RE: NSW EPA AND DPIE REQUEST FOR ADDITIONAL INFORMATION – PROPOSED RESOURCE RECOVERY FACILITY (RRF), 16 TORRENS ROAD, GUNNEDAH

Martens have reviewed the request for additional information (RFI) provided by NSW Department of Planning, Industry and Environment (NSW DPIE), NSW Environment Protection Agency (NSW EPA) and Gunnedah Shire Council (GSC), and provide the following response and additional detail:

DRAWING ID: P19074.34-PS01-R16-E100

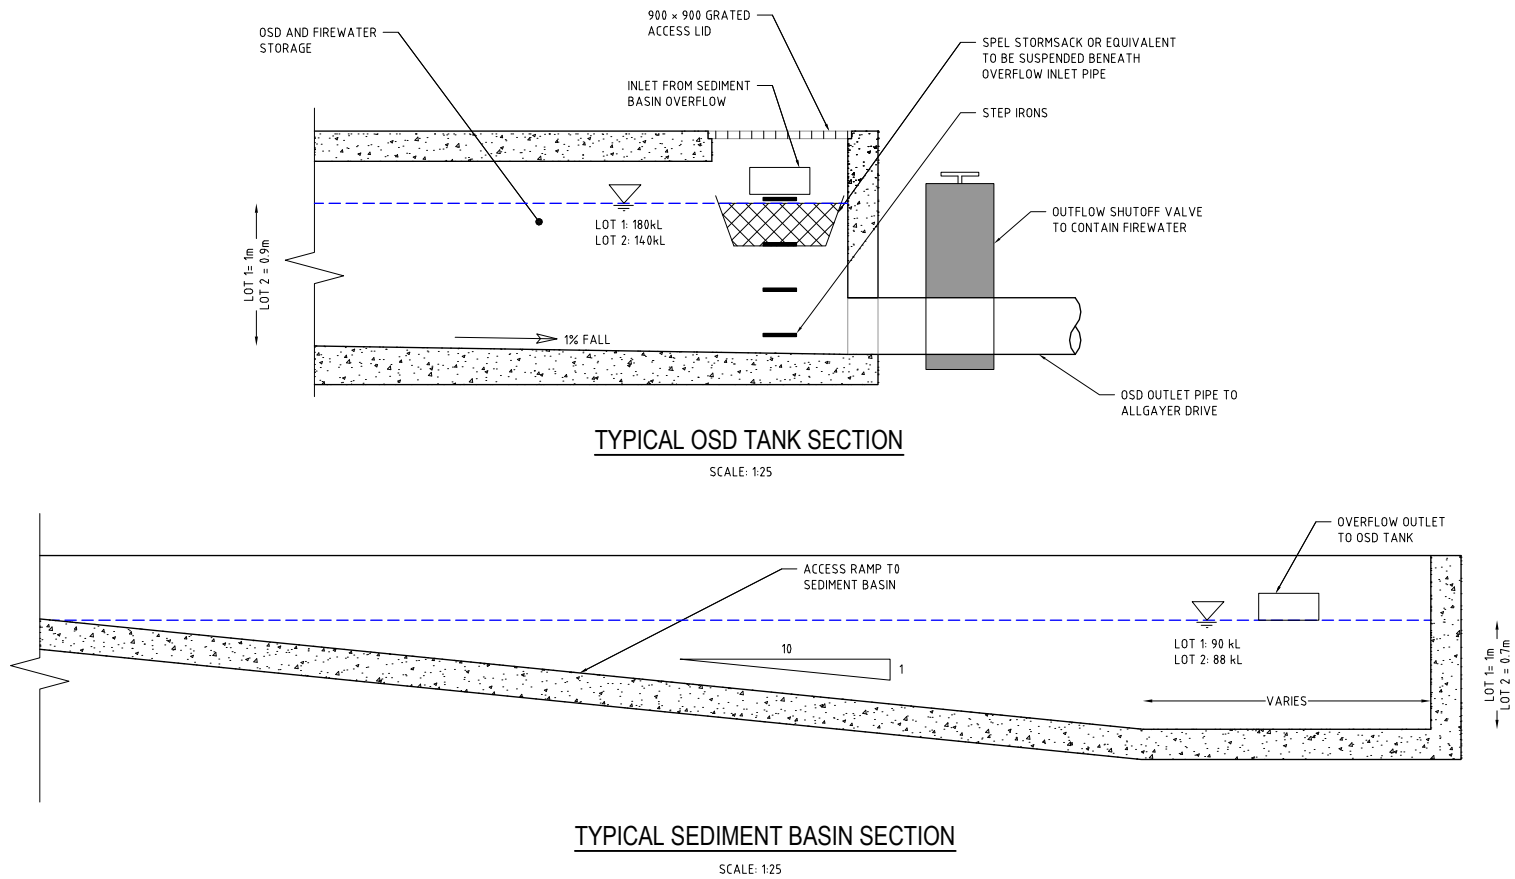
The EPA notes that leachate will be collected in two leachate storage tanks, however, no details of the sizing of tanks or adjacent sumps have been provided. Only limited information has been provided on the leachate collection system and any leachate barrier systems. The EPA requires that any leachate barrier system is at least 1000 mm thick and meets an in situ hydraulic conductivity of 1×10^{-9} metres/second. The EPA recommends that the proponent provide the proposed capacity of the leachate tanks and sumps, as well as expected flow rates to the leachate tanks and sumps. Flow rates should be provided for normal conditions as well as wet weather events. The EPA also recommends that the proponent provide additional information on the design of the leachate barrier system.

Site leachate management system has been designed in accordance with Section 2 of the NSW EPA (2016) *Environmental Guidelines – Solid Waste Landfills* guideline on the advice of Mr Daniel Stokes of the NSW EPA. Specifically, the leachate management system is designed to contain:

1. Direct rainfall falling onto exposed site stockpile areas.
2. In addition to the above, leachate storages include a dedicated volume designed to contain the 1 in 25 year Average Recurrence Interval 24 hour design storm event for Gunnedah.

From the above analyses, the estimated leachate tank volume required is 151 kL for Lot 1 and 90.5 kL for Lot 2 respectively. Refer to Attachment A, drawing E100 (ref: P1907434PS01-E100) for concept leachate management details.

C	MINOR AMENDMENT	14/07/2020	RK	AW/AVG	SL	TH						DRAWING ID: P1907434-PS01-R16-G400	
B	UPDATED AS PER CLIENT COMMENT	25/06/2020	GM	AW/AVG	SL	TH							
A	INITIAL RELEASE	28/05/2020	GM	AW/AVG	SL	TH

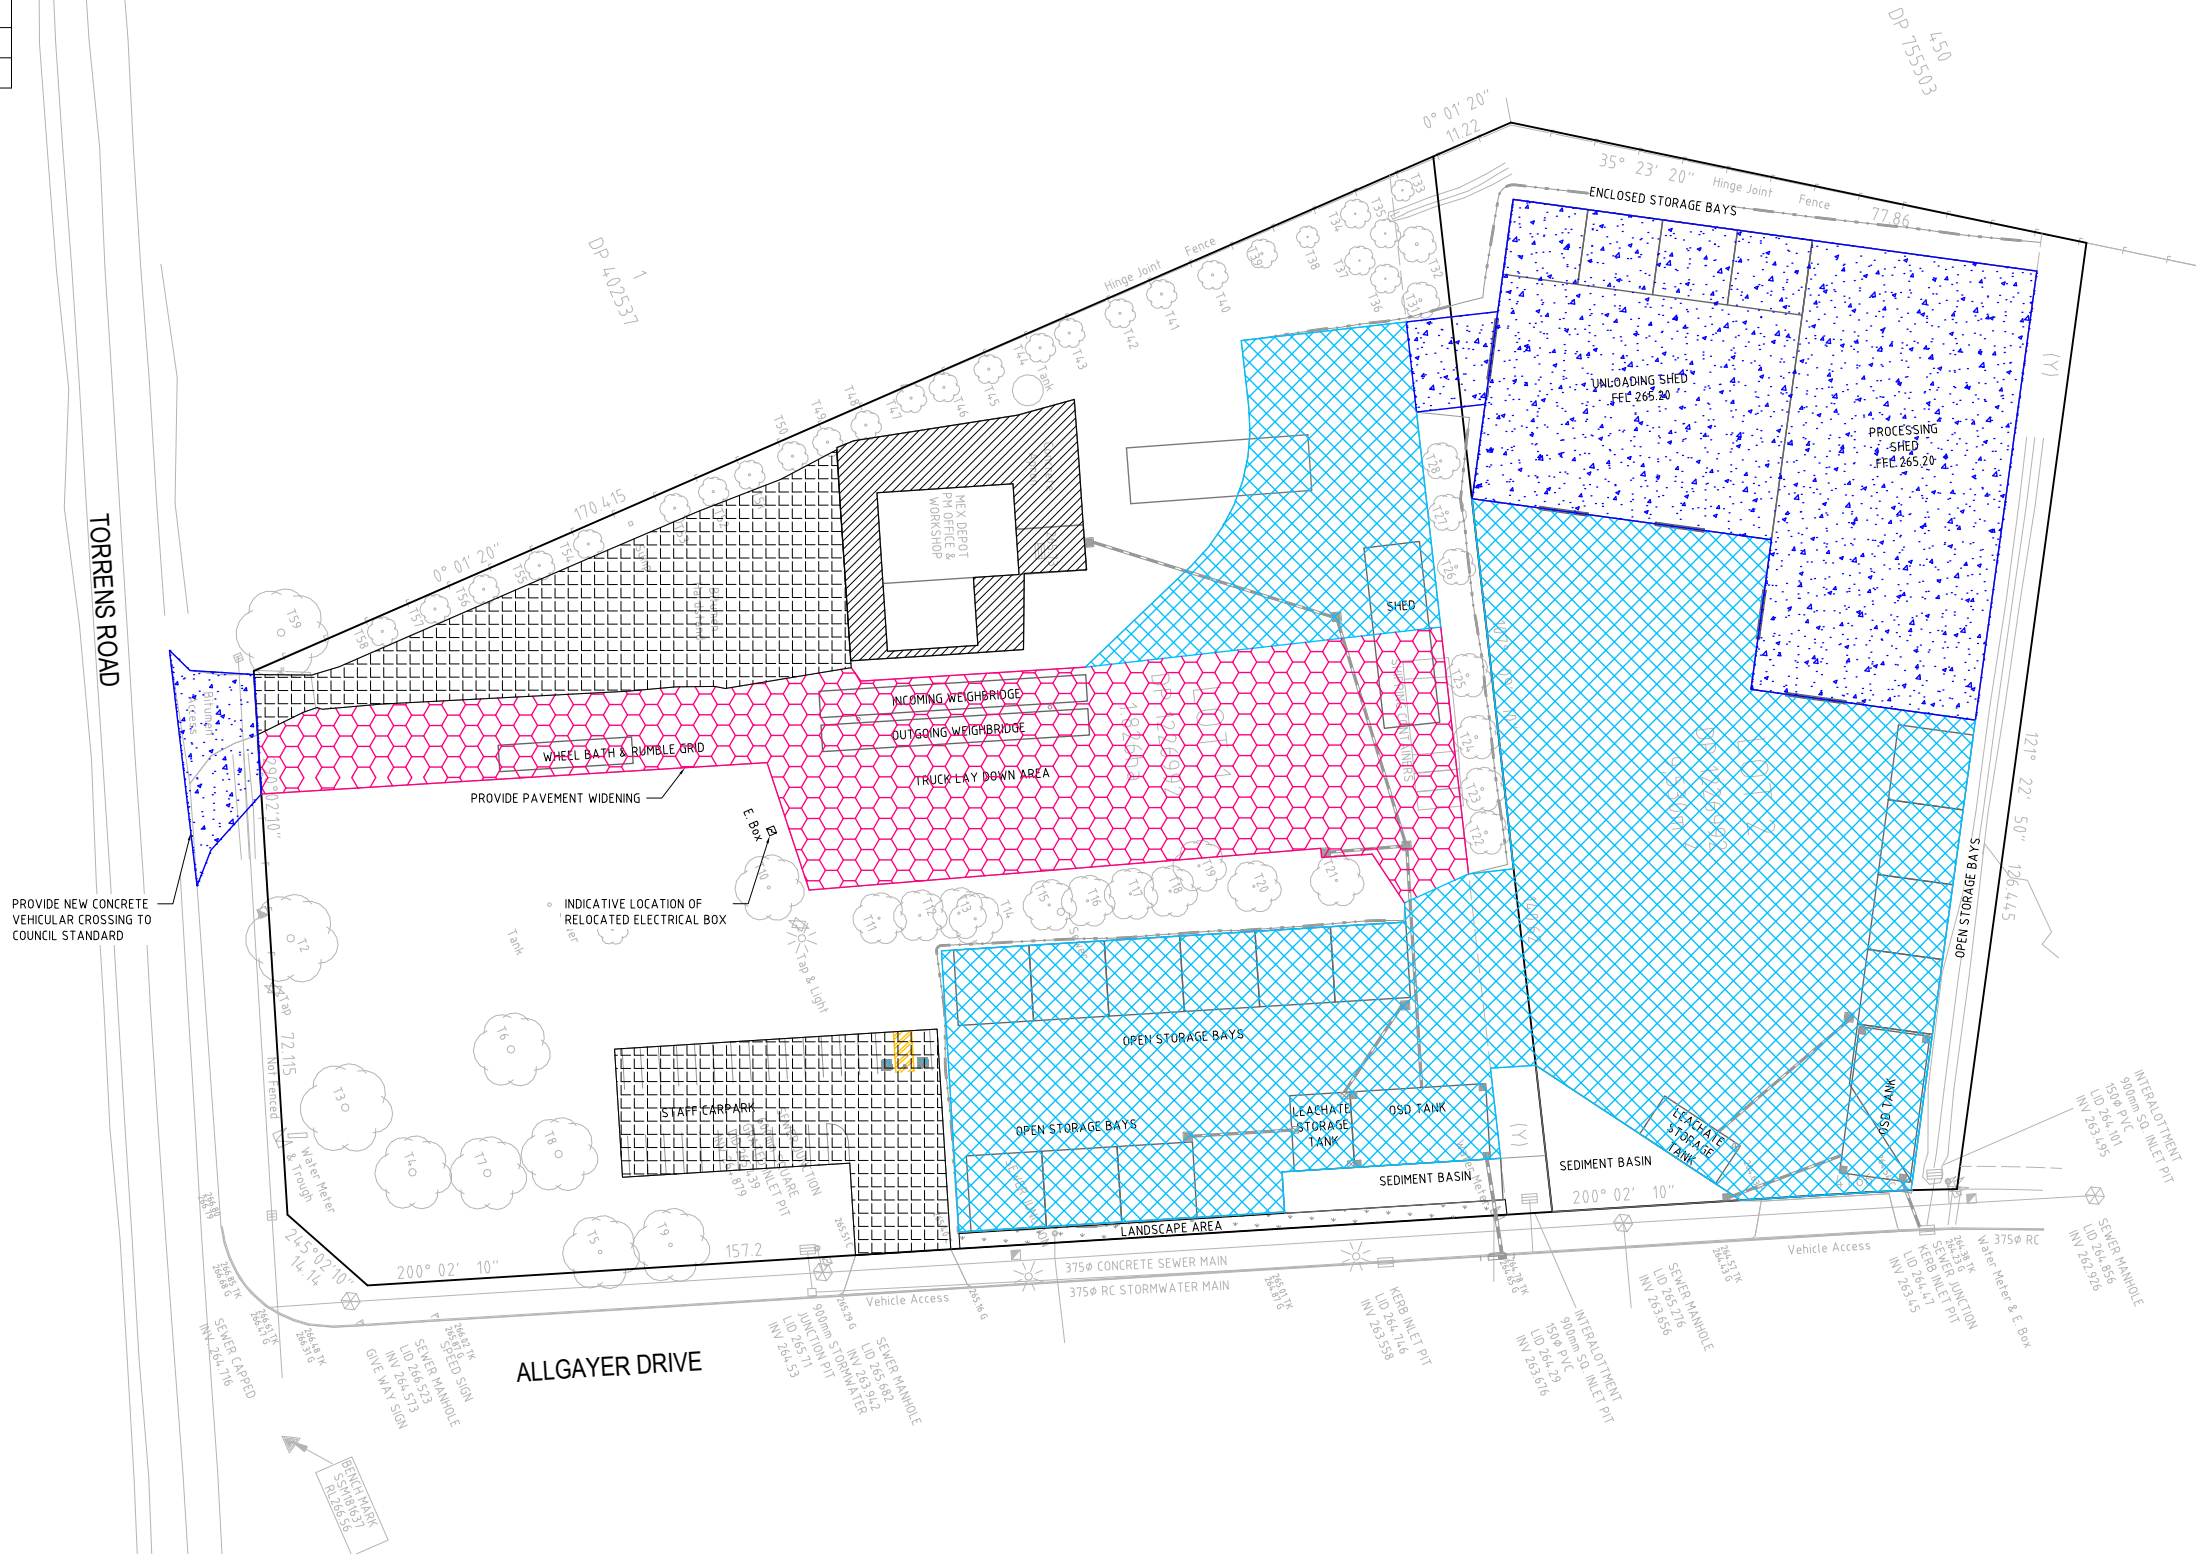
Frontage along Torrens Road is to be constructed with kerb and gutter and road shoulder for the full frontage of the development site.

The development has not adequately addressed onsite parking demand for the lands proposed additional land use. Parking for this development should be in addition to existing parking requirements. Council requests that a detailed parking layout, complying with AS2890.1 be prepared and submitted as part of this development, accommodating the minimum number of spaces required onsite.

All internal circulation driveways and parking areas are to be paved, and the existing access via Torrens Road to be upgraded to a concrete vehicular crossing. Pavement details to be provided at detailed design stage of the development.

Details of Torrens Road upgrade along the site frontage are to be provided at detailed design stage of the development.

Refer to Attachment A, drawing G400 (ref: P1907434PS01-G400) for the pavement plan.

DRAWING TITLE				
SWEEP PATH ANALYSIS PLAN - AV				
PROJECT NO.	PLANSET NO.	RELEASE NO.	DRAWING NO.	REVISION
P1907434	PS01	R16	PS01-GZ00	L

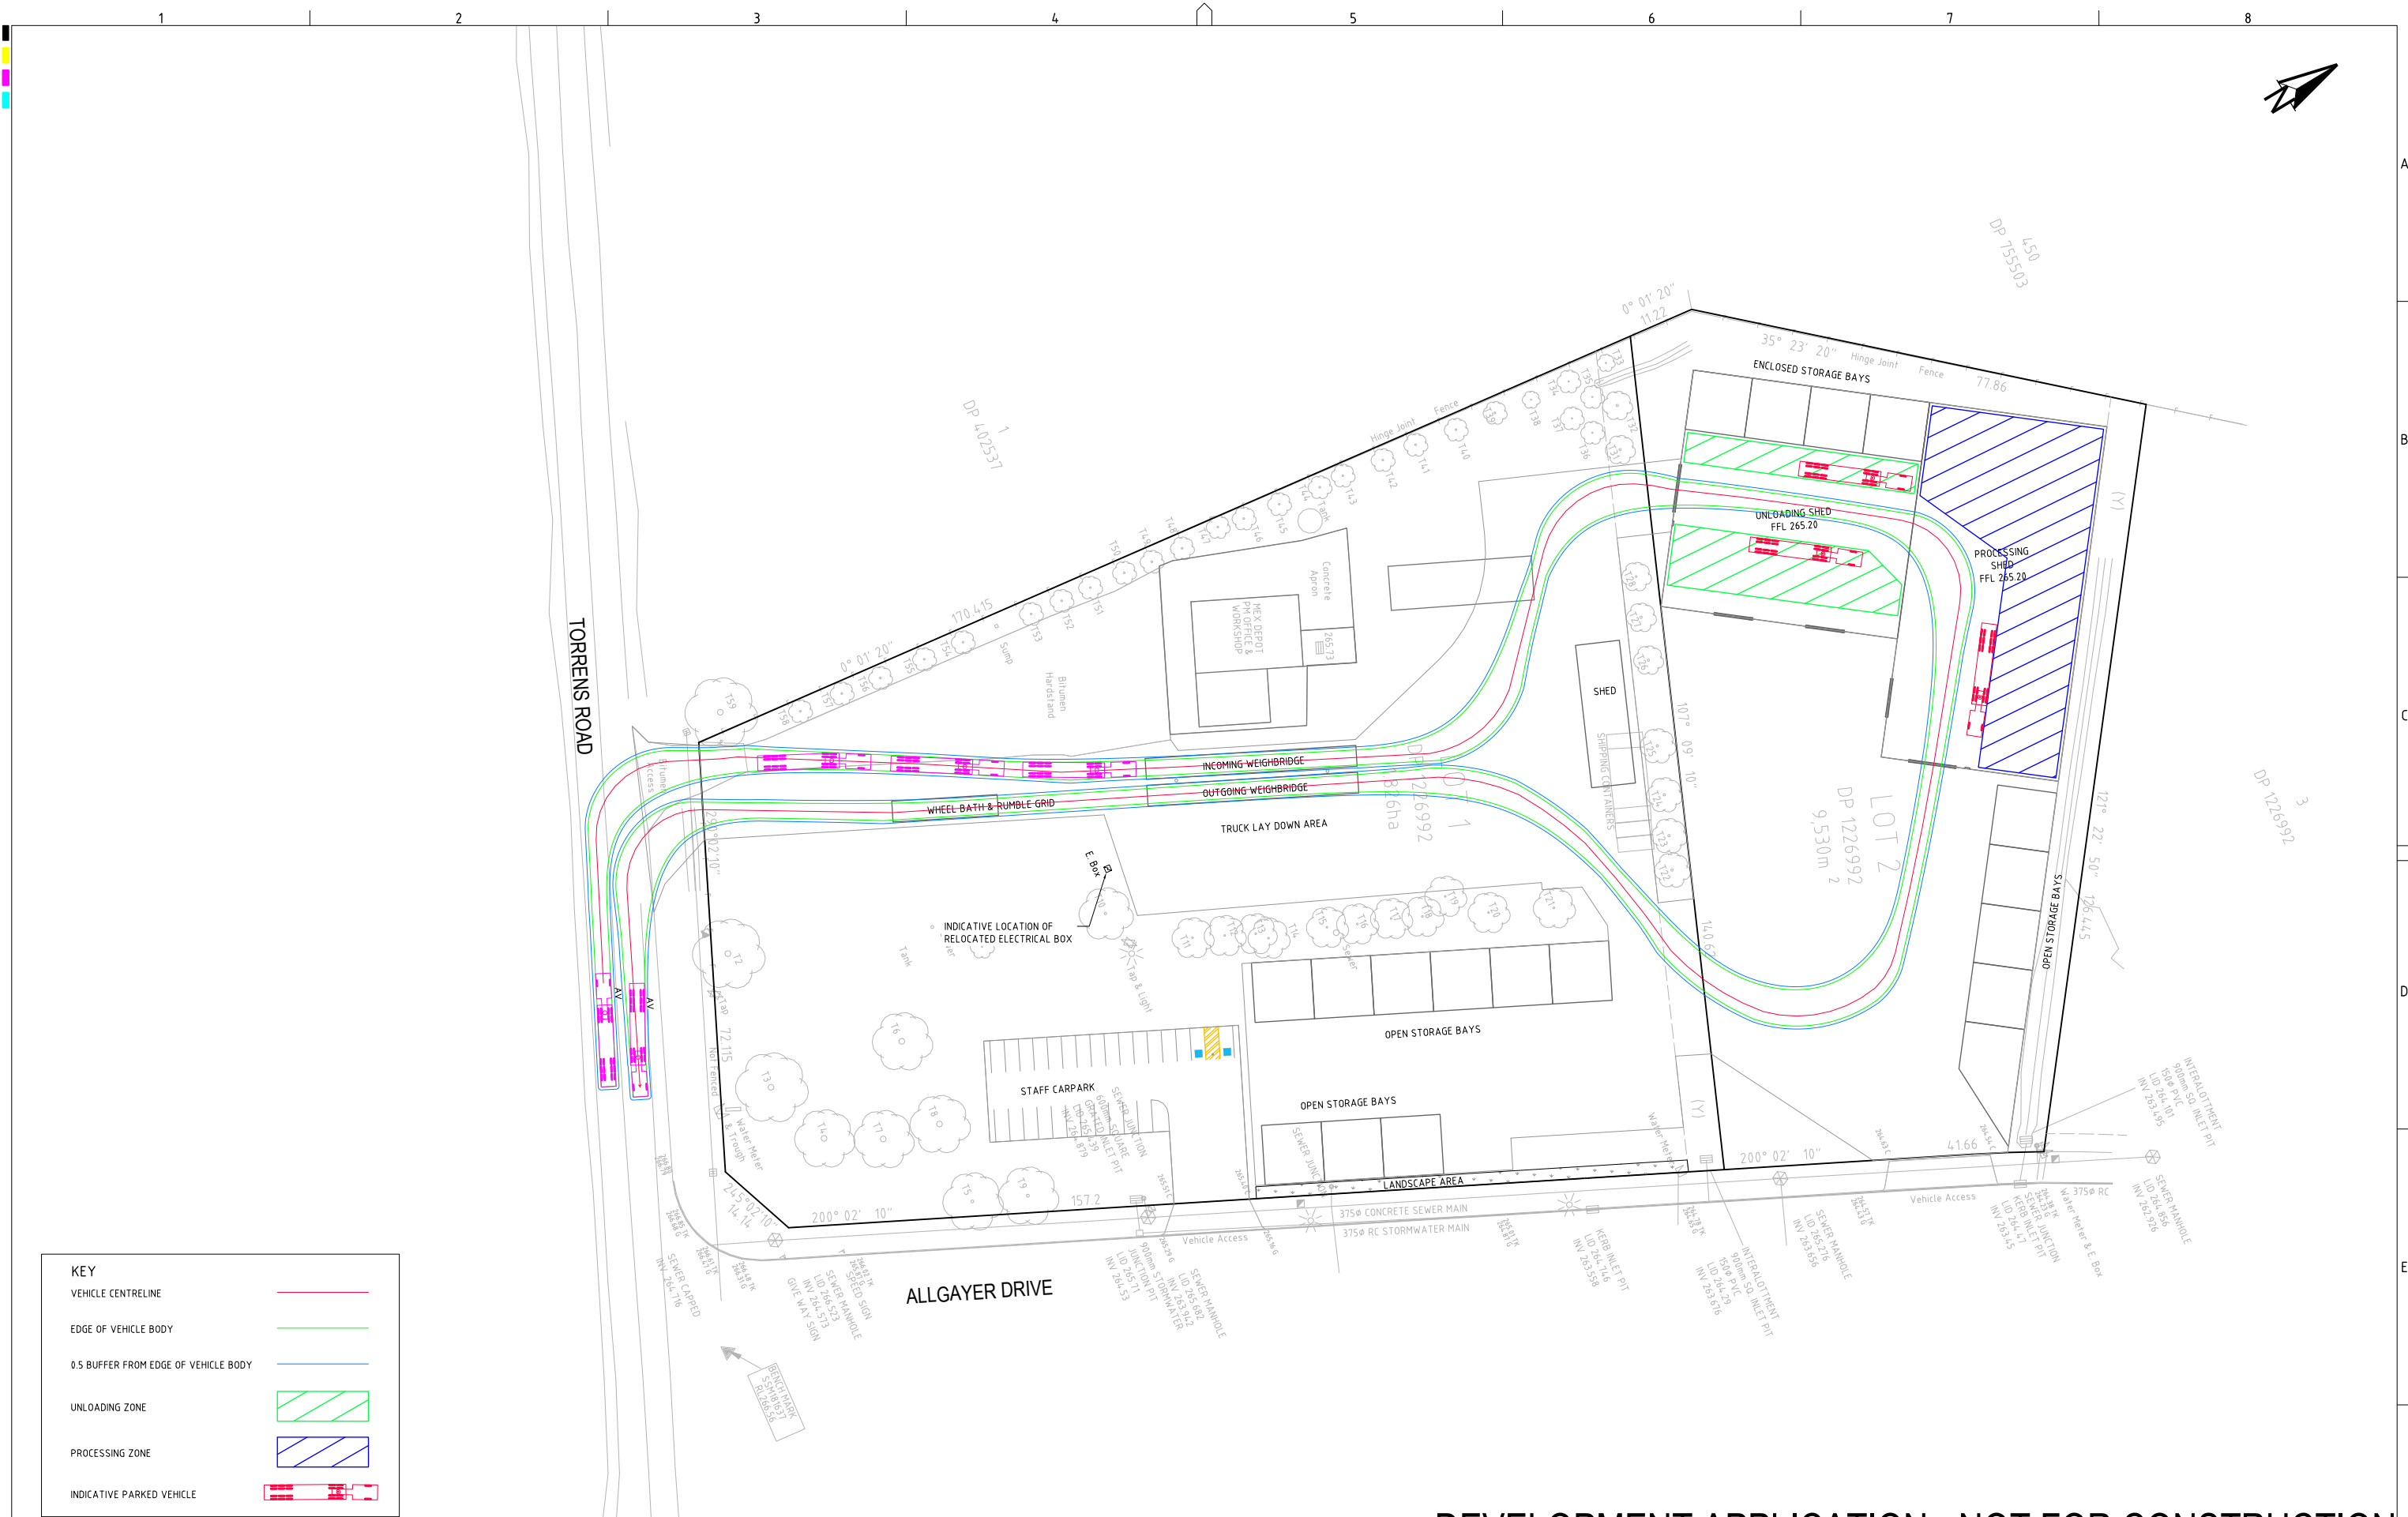
Confirm the largest vehicle expected to enter the site and provide swept paths for this vehicle. Please provide swept path diagrams showing vehicles exiting the site onto Torrens Road.

All swept paths indicate that adequate manoeuvring is achieved within the site and demonstrate that all vehicles can enter and exit the site in a forward direction.

Refer to Attachment A, drawings GZ00 to GZ50 (ref: P1907434PS01-GZ00 to GZ50) for swept path plans.
